OXFORDSHIRE COUNTY COUNCIL'S RESPONSE TO CONSULTATION ON THE FOLLOWING DEVELOPMENT PROPOSAL

Application no: 15/01612/REM

Proposal: Reserved Matters to 10/01642/OUT - Erection of 86 dwellings with associated car parking, infrastructure. associated works and public open space

Location: Phase 4 And Phase 5B South And South West Of Wellington Road Upper Heyford

TYPICAL SWALE DETAIL

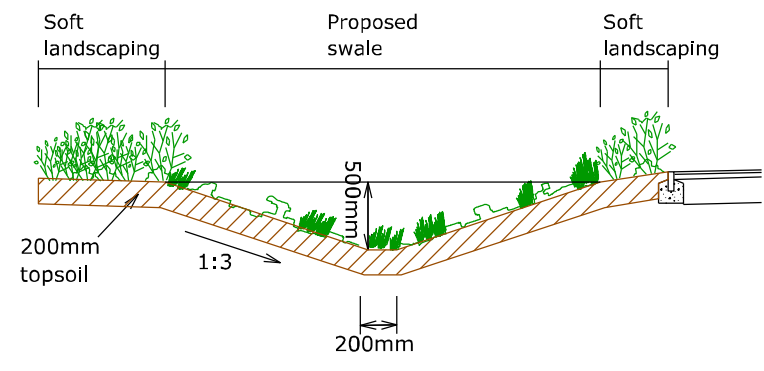
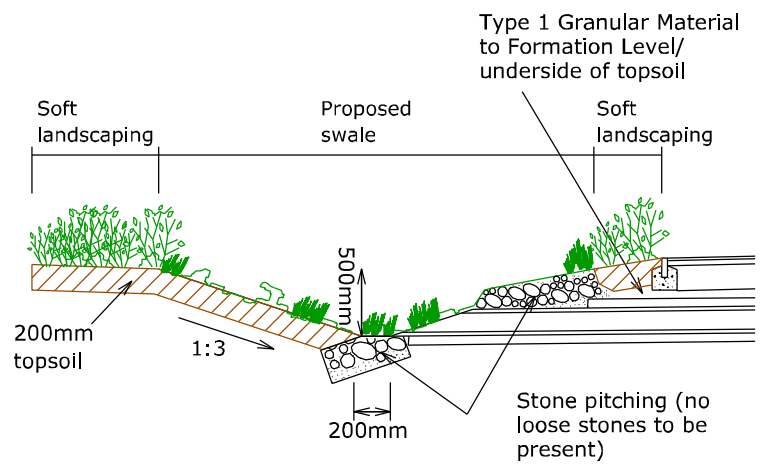
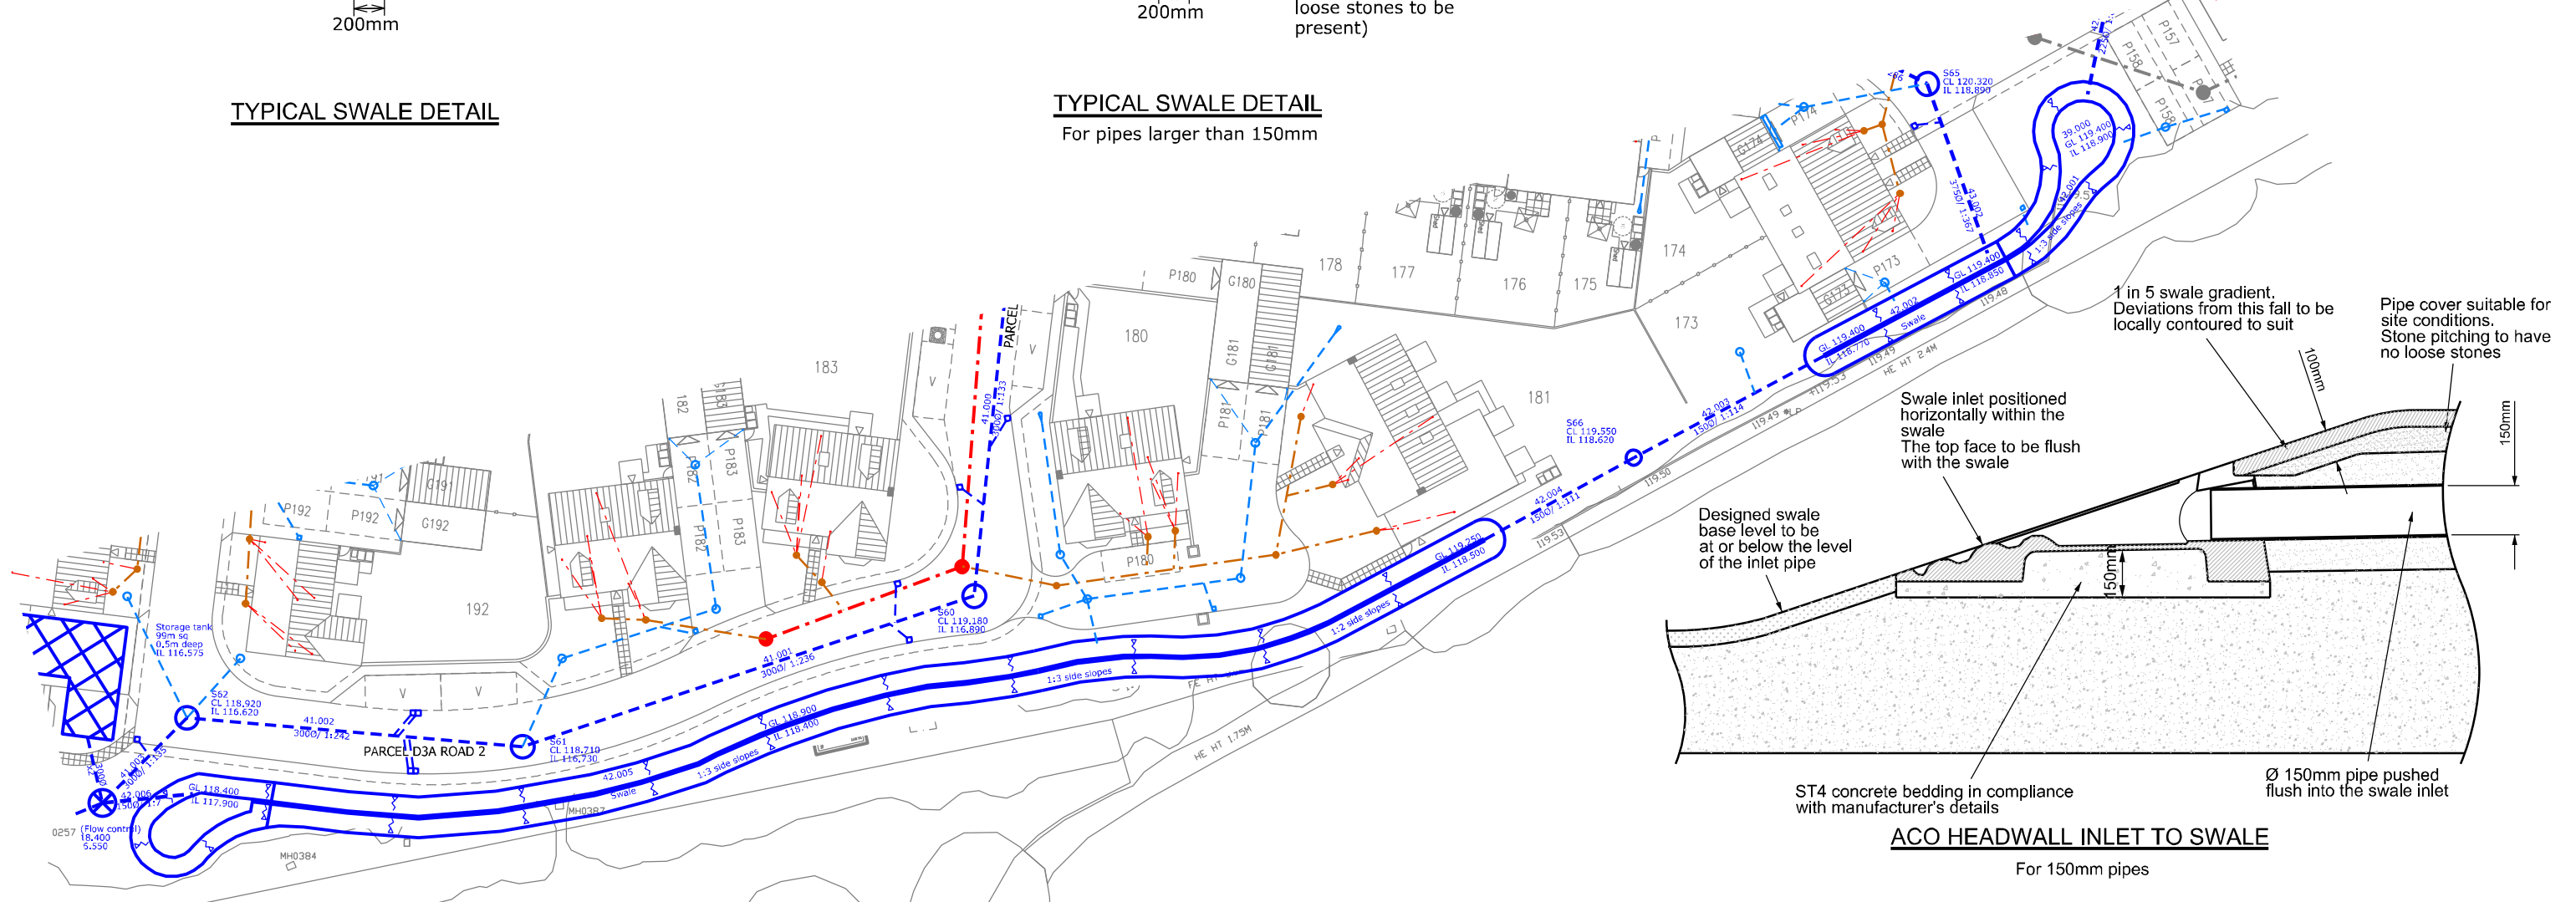
Insufficient drainage information has been provided with the planning application. The planning application should include enough information to demonstrate a workable solution for managing surface water drainage.

Development shall not begin until a surface water drainage scheme for the site, based on sustainable drainage principles and an assessment of the hydrological and hydro-geological context of the development, has been submitted to and approved in writing by the local planning authority. The scheme shall subsequently be implemented in accordance with the approved details before the development is completed. The scheme shall also include:

- Discharge Rates;
- Discharge Volumes;
- Maintenance and management of SUDS features (this may be secured by a Section 106 Agreement);
- Sizing of features – attenuation volume;
- Infiltration in accordance with BRE365;
- Detailed drainage layout with pipe numbers;
- SUDS (list the suds features mentioned within the FRA to ensure they are carried forward into the detailed drainage strategy);
- Network drainage calculations;
- Phasing.
